DESIGNERS RESPONSE

Fullwood Drive, Golcar, Kirklees

Road Safety Audit Stage 1

2023-09 Golcar RSA1 – Revision 0

Description: PROPOSED SITE PLAN & 3D VIEW

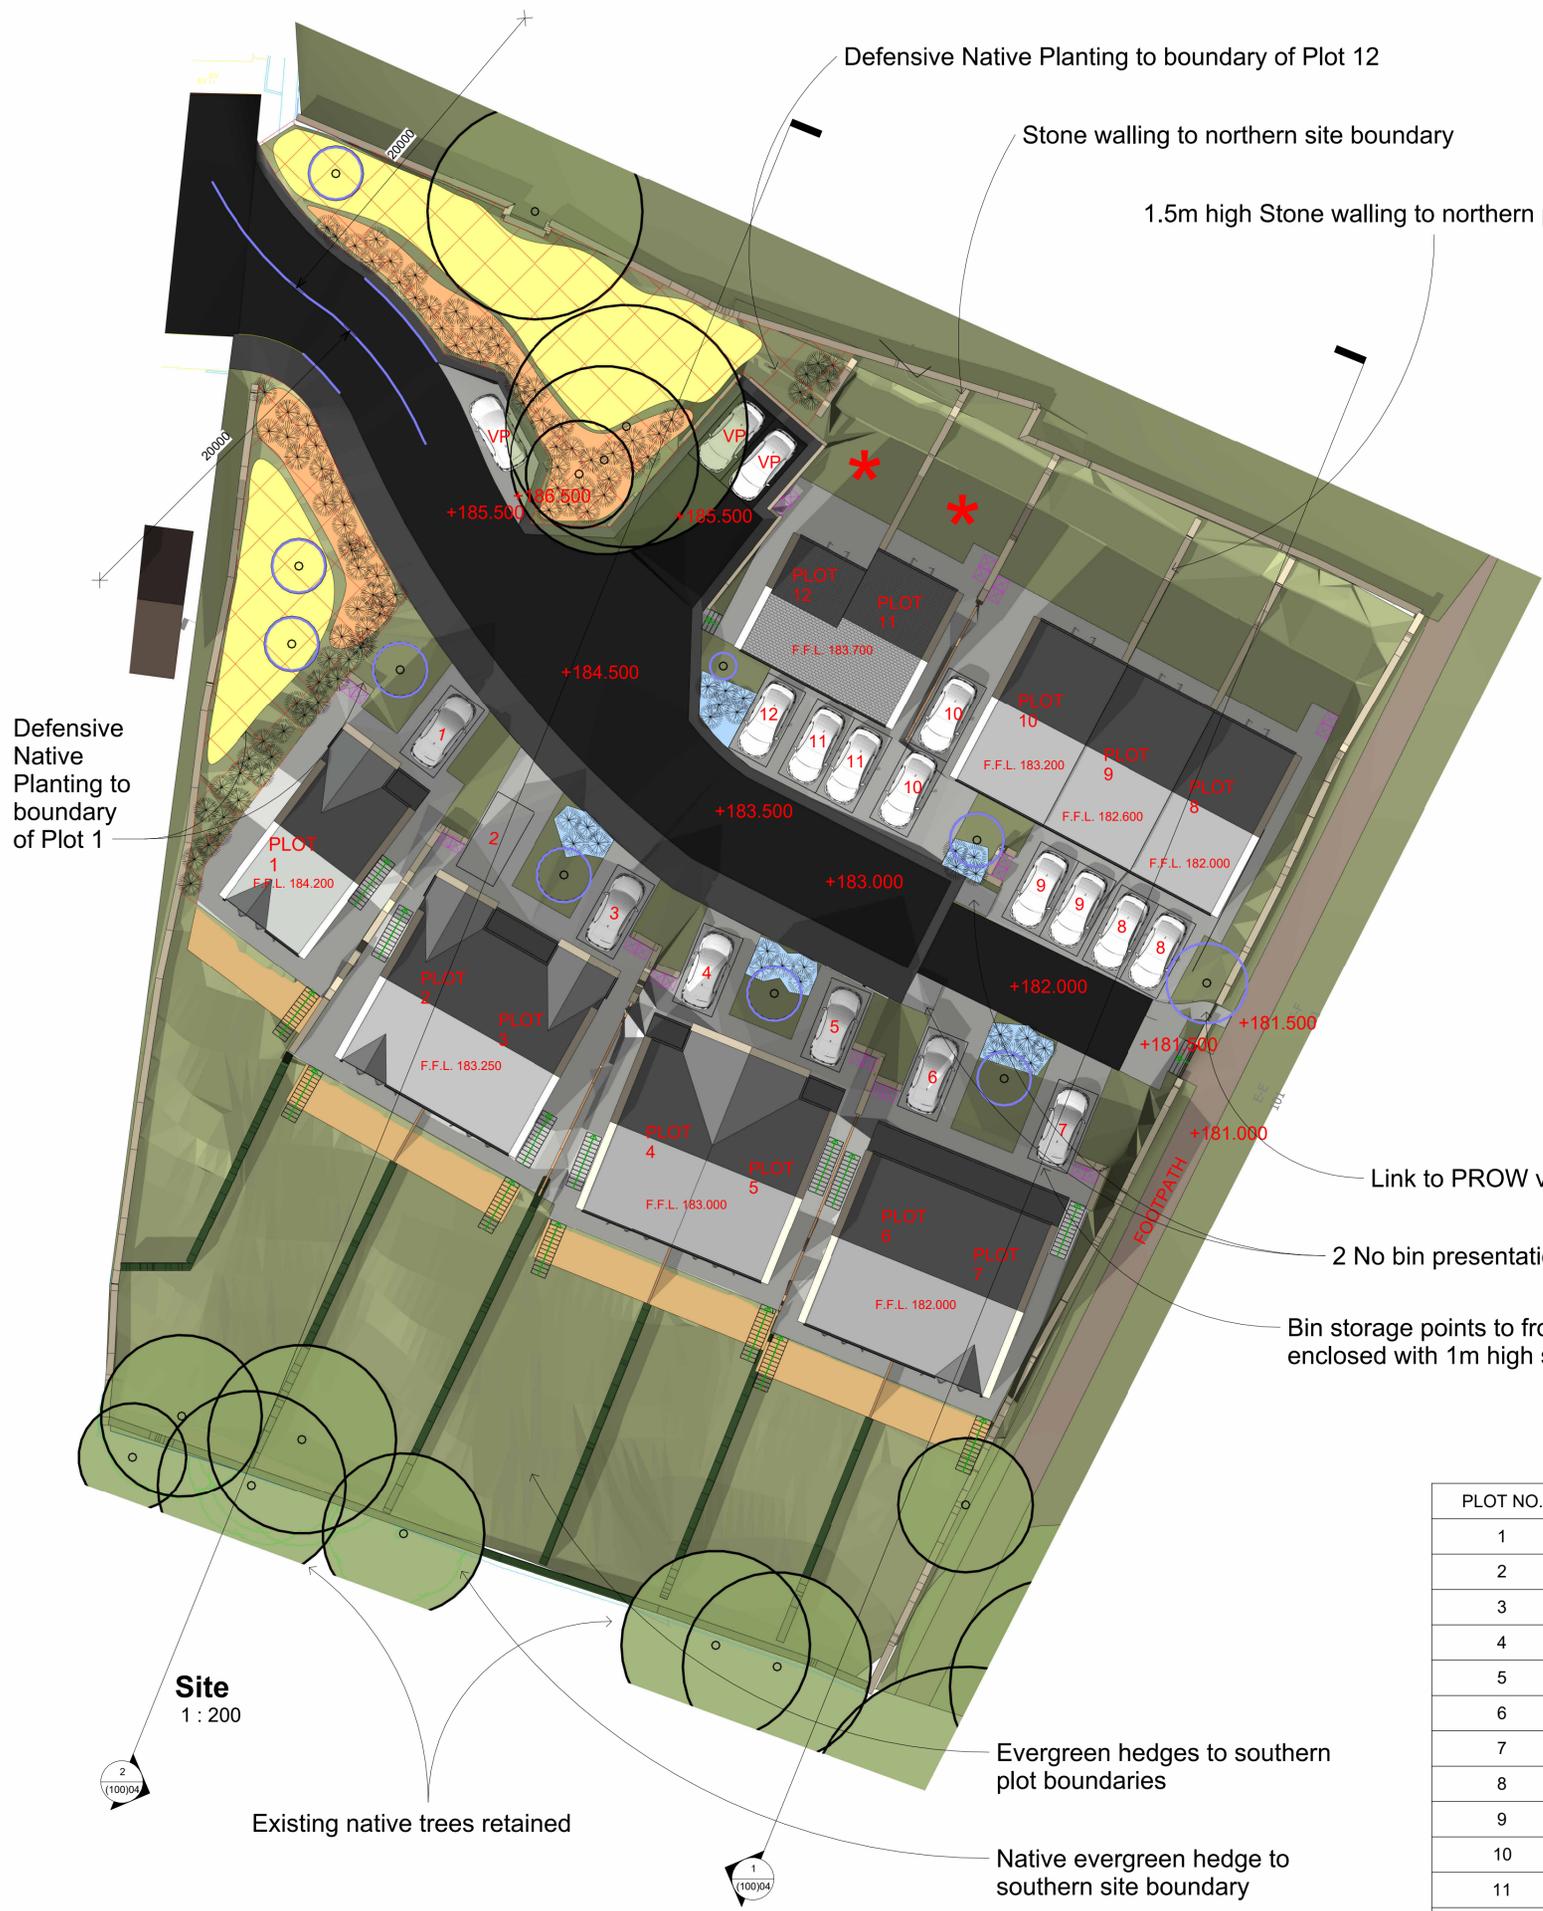
Location: Internal estate road

Summary: Skidding Resistance – Insufficient skidding resistance may increase the risk of collisions involving skidding

Although no long sections have been provided at this early stage, the levels on the internal road suggest that the gradients could be 10% or more. This may increase the risk of collisions involving vehicles not having sufficient skidding resistance, especially during wet or wintry conditions. Insufficient provision, especially in higher risk areas such where gradients exceed 10% may increase the risk that collisions involving skidding occur.

It is recommended that surfacing with a 60 PSV is provided through the entire length of the estate road.

Location: Internal estate road

Summary: Drainage – Ineffective surface water drainage may increase the risk of skidding type collisions

At this early stage, no details have been provided on the proposed surface water drainage arrangements other than an indication of grade on the general arrangement. It was noted that there is the potential for low points on the estate roads where surface water may not effectively drain, specifically at the eastern end of the internal estate road. This may increase the risk of slips and falls by pedestrians or skidding type collisions in these areas due to excessive surface water, especially in wintry conditions.

It is recommended that drainage details are provided at the next stage of road safety audit including levels, contours and gully locations.

Location: Internal estate road

Summary: Lighting – Lack of or insufficient carriageway lighting may increase the risk of collisions, trips and falls during the hours of darkness.

It is unclear from the information provided if any carriageway lighting is to be provided. A lack of carriageway lighting or insufficient levels of light may increase the risk of collisions between vehicles and active mode users as well as trips and falls by pedestrians during the hours of darkness.

It is recommended that carriageway lighting is provided.

Accepted – suitable PSV shall be identified and agreed with the Council's Road Adoption Engineers as part of the detailed design process

Accepted – drainage details shall be identified at detailed design stage

Accepted – street lighting details shall be identified at detailed design stage and shall meet the Council's adoptable standards
